Botany Report
commissioned by the
Save Crossness
Nature Reserve
campaign

Including: an evaluation of Cory's *EN010128-000178-6.3 Environmental Statement - Appendix 7-2 - Preliminary Ecological Appraisal, EN010128-000182-6.3 Environmental Statement - Appendix 7-6 - Botanical Survey Report* and associated documents; and a Botany Survey undertaken by Dr M.A. Spencer on the 7th and 20th August 2024.

By Dr Mark A. Spencer FLS

1. EN010128-000178-6.3 Environmental Statement - Appendix 7-2 - Preliminary Ecological Appraisal [PEA]

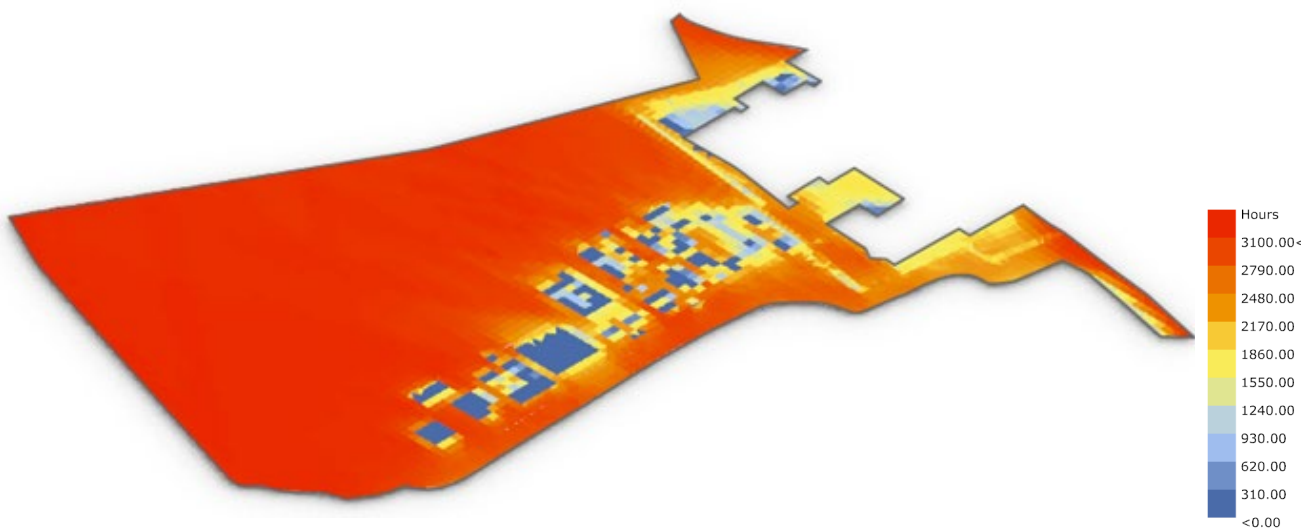
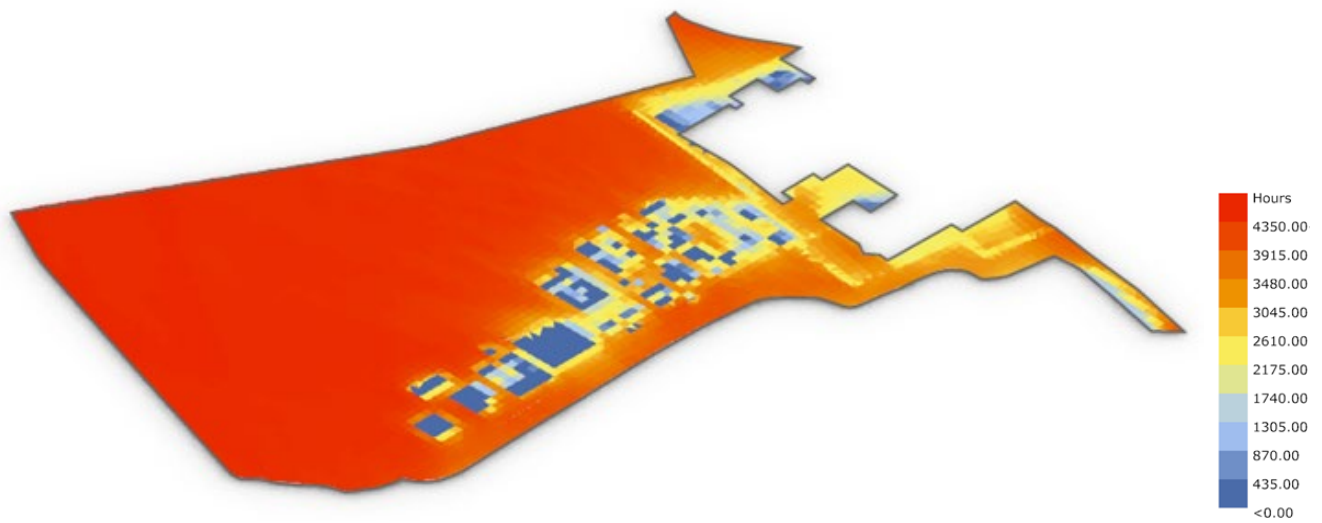
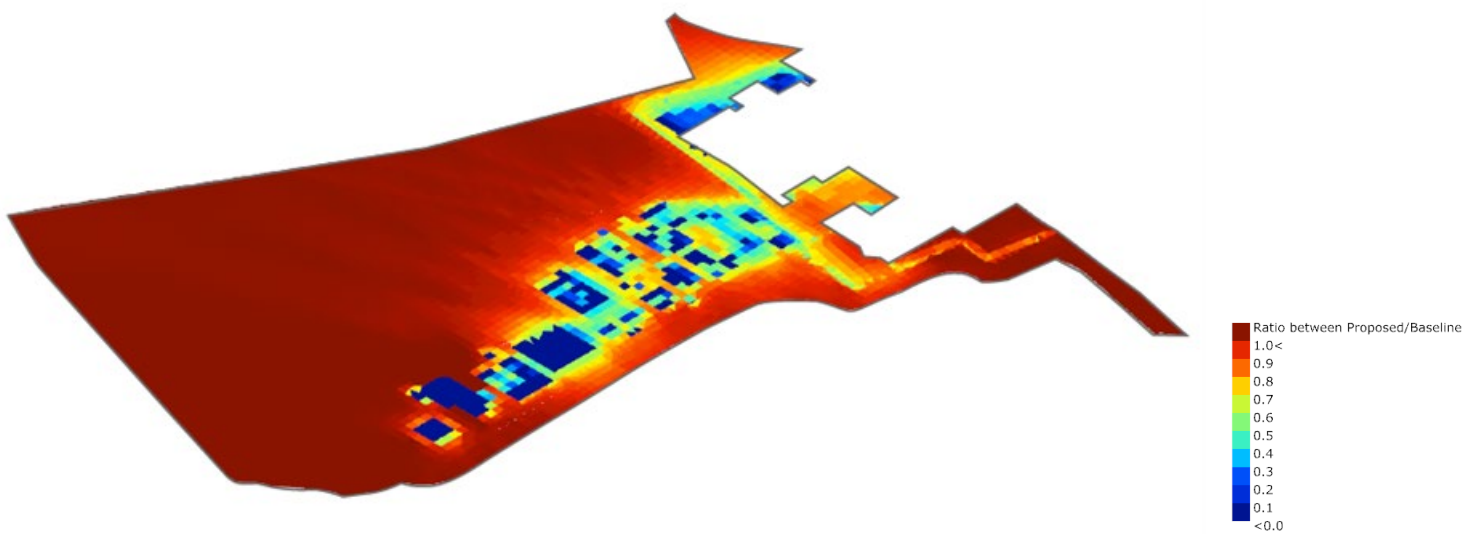
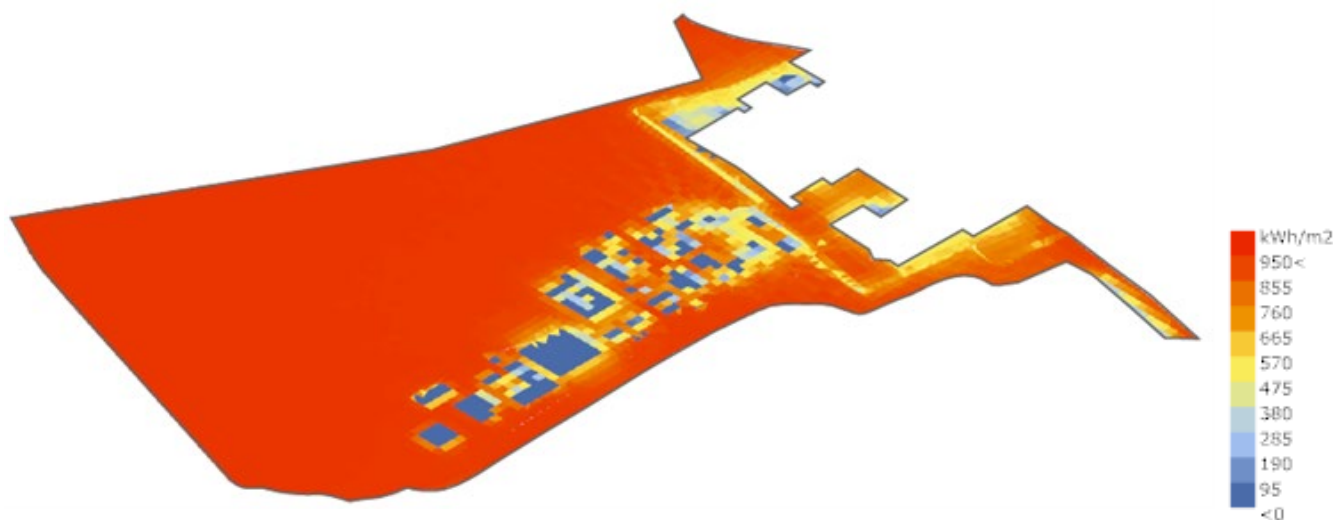
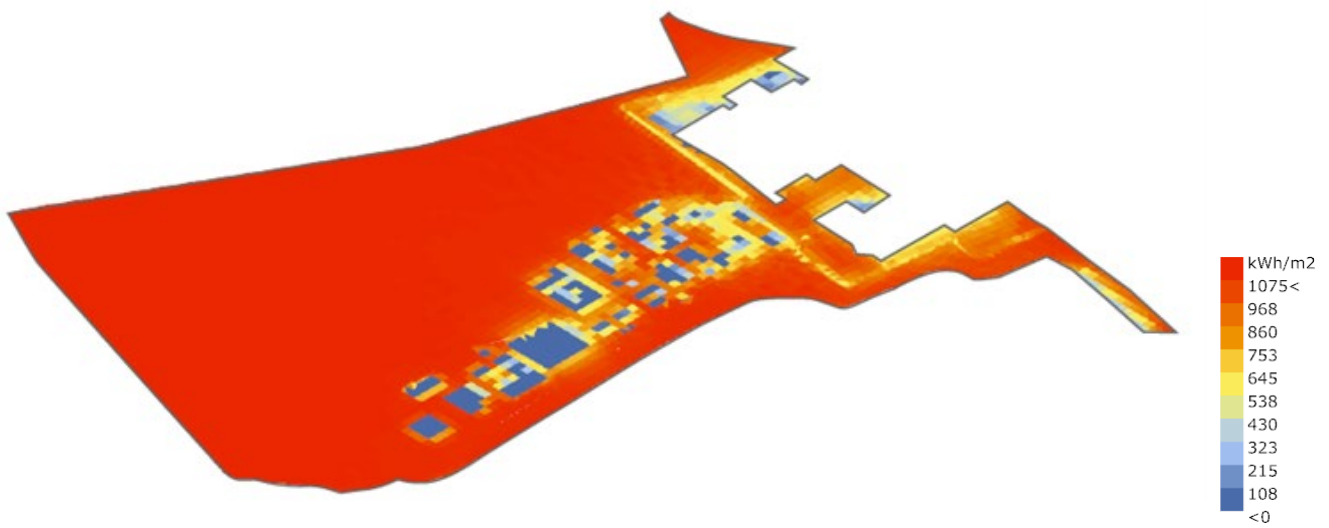
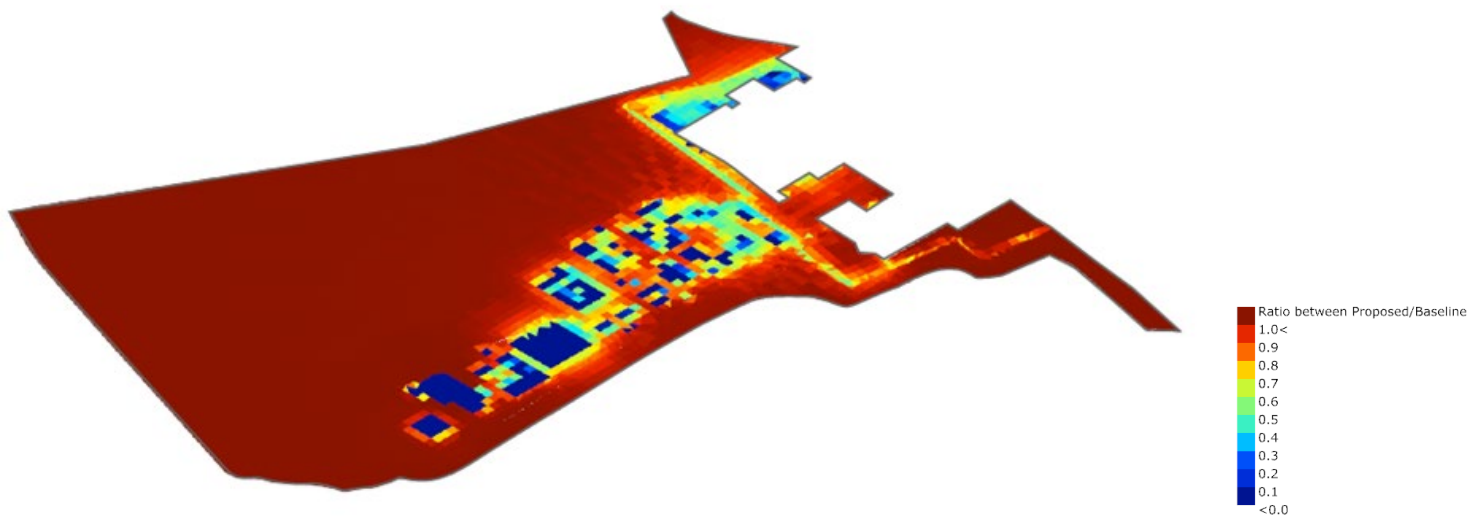
MS comment - The study indicates that there will be reduction in sunlight in the vicinity of the building – this reduction in light may negatively impact remaining populations of regionally scarce plants on site, particularly Divided Sedge (*Carex divisa*), Narrow-leaved Pepperwort (*Lepidium ruderale*), Borrer's Saltmarsh-grass (*Puccinellia fasciculata* var. *pseudodistans*) & Round-fruited Rush (*Juncus compressus*). However, the graphic representations are heavily foreshortened and therefore the extent of light loss is hard to assess; this is because the foreshortening does not enable the extent (in square metres) or duration to be established. Consequently, it is not possible to assess the impact of reduced light upon the remaining Habitats of Principal Importance following construction. However, it is important to recognise that the two main HPs affected by shading are likely to be the Reedbeds and the Grazing Marsh – the health of both habitats is highly reliant upon high light levels because key species, especially grasses, such as Common Reed (*Phragmites australis*) are intolerant of heavy shading.
